Meeting note

Project name	A63 Castle Street
File reference	TR010016
Status	Final
Author	The Planning Inspectorate
Date	1 August 2018
Meeting with	Highways England
Venue	Teleconference
Meeting objectives	Project Update Meeting
Circulation	All attendees

A63 Castle Street Improvement: Comments on draft documents, July 2018

Drawing Title
LAND PLANS REGULATION 5(2)(i) SHEET 3 OF 6

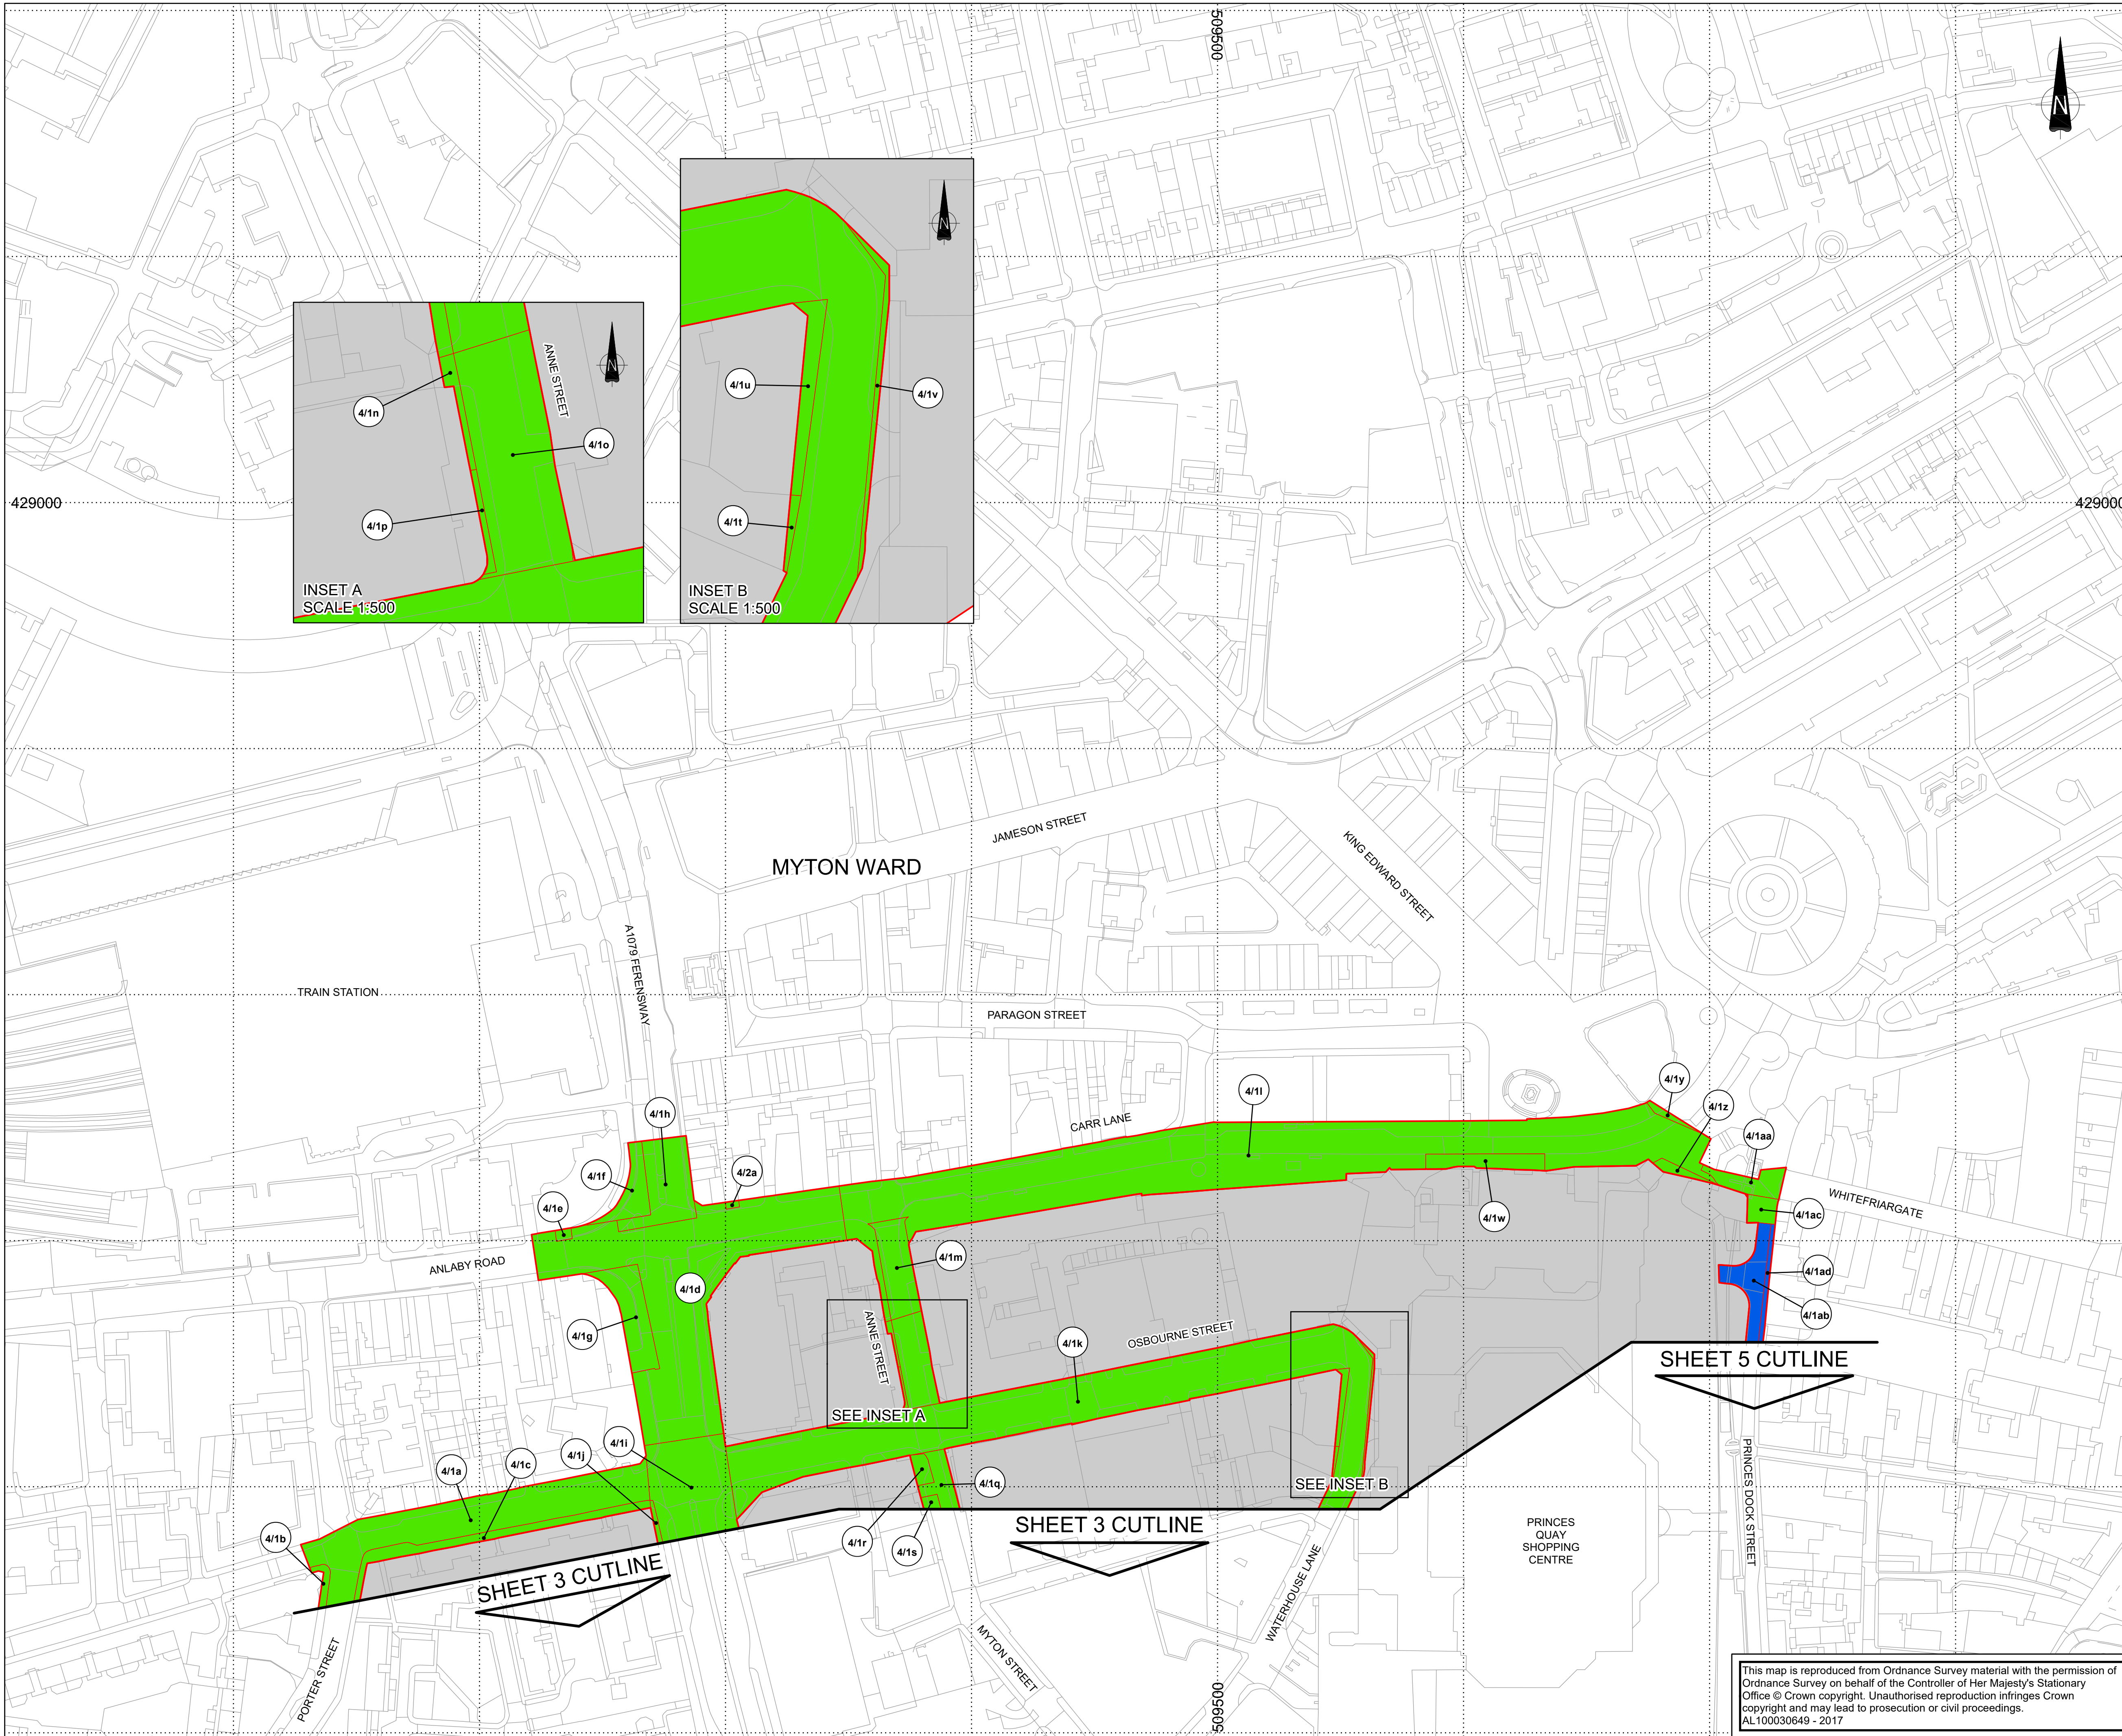
Q No .	Section	Extract from Document	Question/Comment
1	General	<i>The use of insets</i>	There are a large number of insets, but they appear clearly and easy to understand.
2	General	<i>The presentation of options</i>	It is clear that two options are being presented, however (particularly on Sheet 3) it is not clear if plot numbers are being duplicated across options; it appears that each plot number is correctly unique. However, some areas of land will appear in two plots as a result.
3	Key Plan	<i>The illustration of the areas covered by sheets</i>	At present, the areas covered by sheets are not shown on the Key Plan itself, but rather on a 'schematic inset'. This is not clear.
4	General		There are several plots that do not appear to be shown, or where the description in the book of reference does not correspond to the plot shown on the land plans. This is presumably a result of the draft nature of the plans and will be corrected prior to submission.
